From: David Innes
Sent: 13 July 2017 10:20
To: Planning.Responses
Subject: FW: objection to A/11/17/OUT

Re: A/11/17/OUT

Our company Store Property owns the land to the East and West of this application site. We would like to raise the following objections to the email submitted by Paul McLaughlin on behalf of the applicant (10.07.17) :

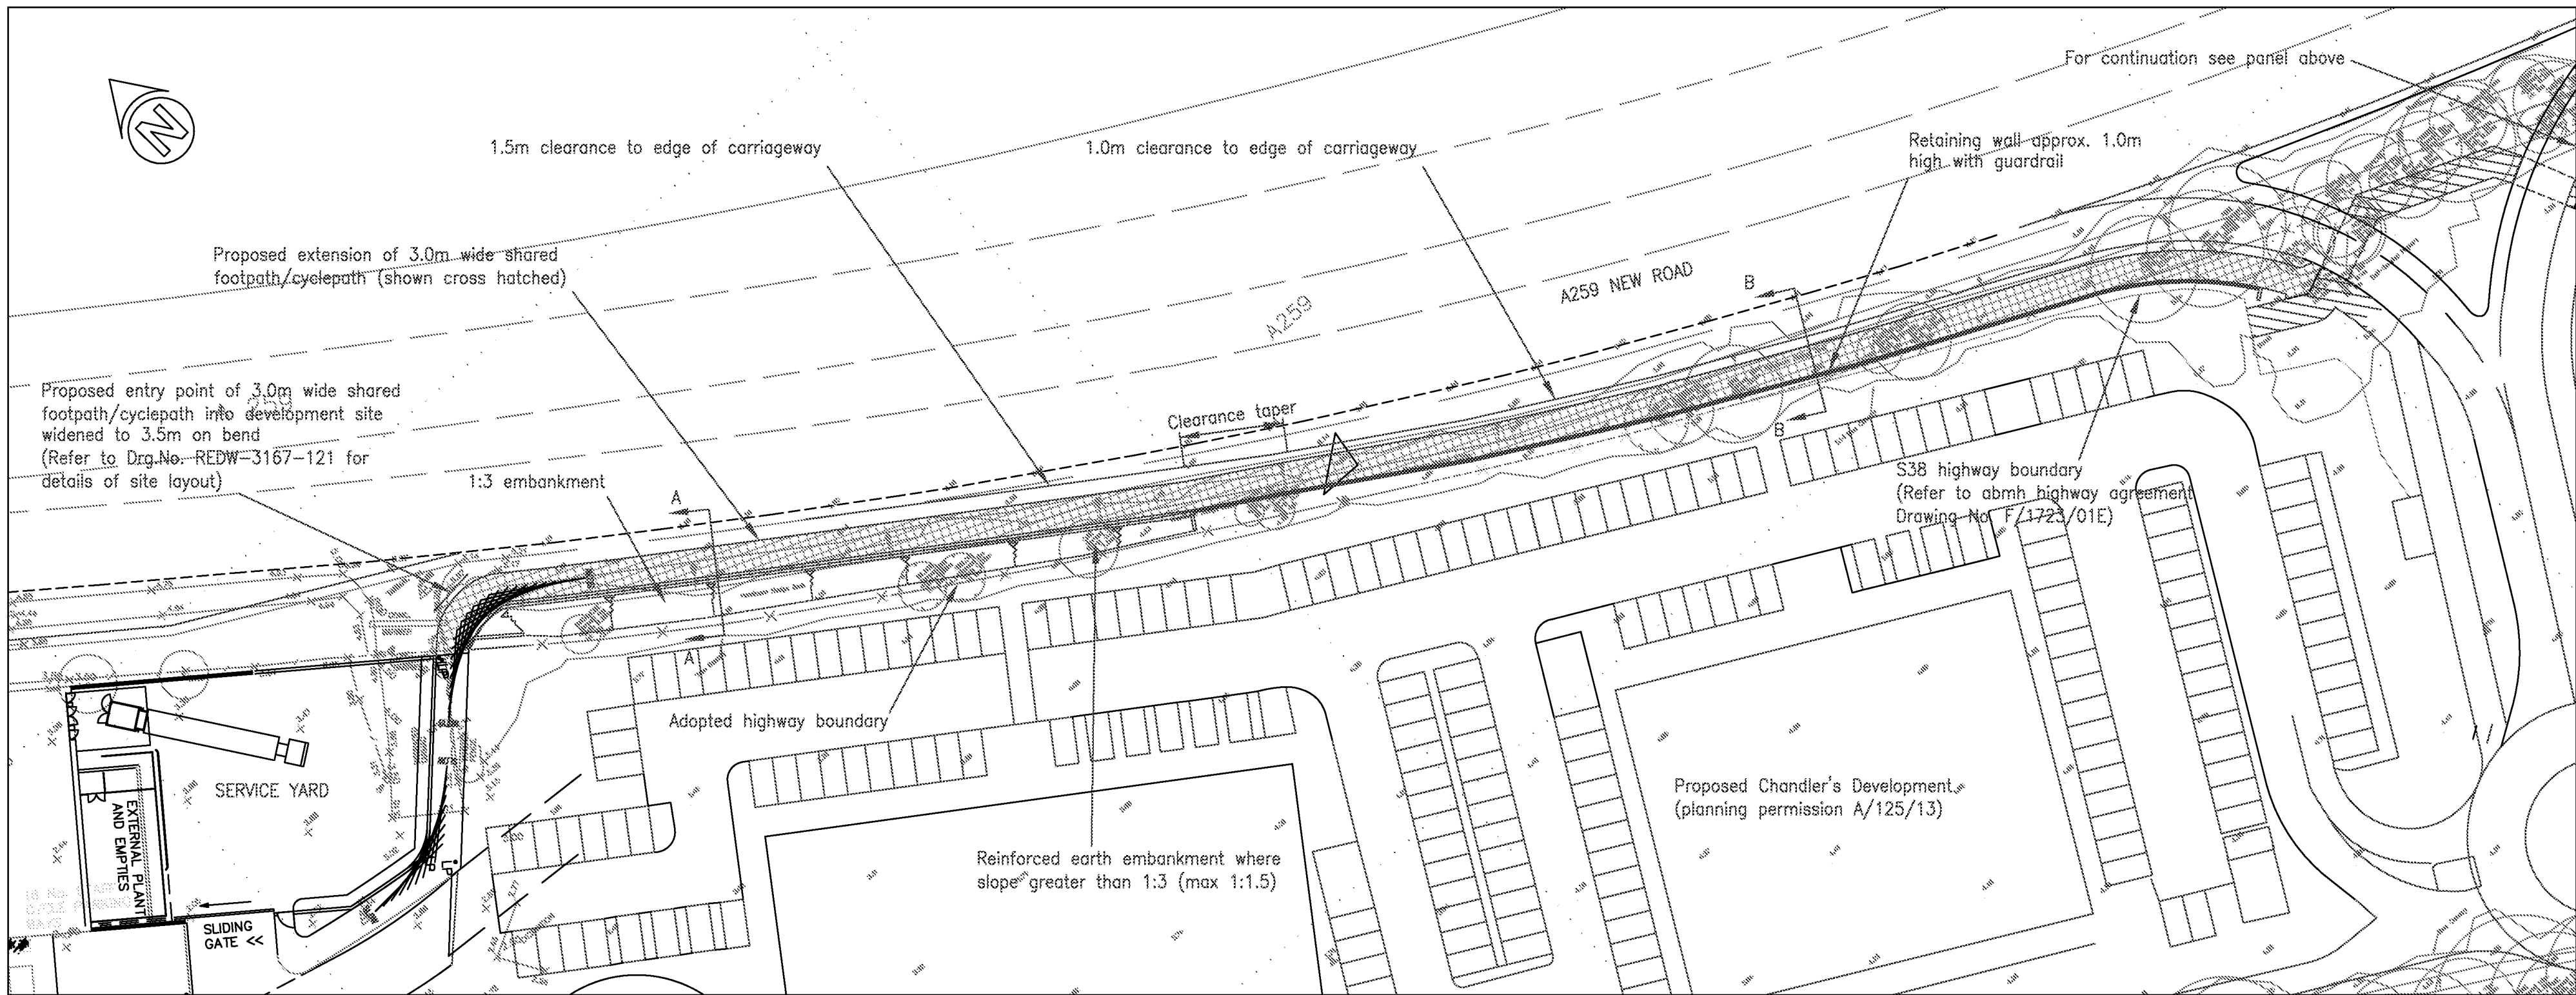
In his point no. 1 which refers to their drawing REDW-3167-120A, Mr McLaughlin states that '*the cycle lane shown on Mill Lane does not form part of our works and was installed as part of the adjacent car sales showroom planning permission. It has now been installed and is therefore part of the existing road markings*'.

- This is incorrect. The adjoining site has been developed and now trades as Manor Retail Park. As part of this development a footpath / cycleway was provided which falls entirely within the privately owned land of the retail park and not highway land.

The Cycle lane shown on REDW-3167-120A should form part of the applicants proposed development.
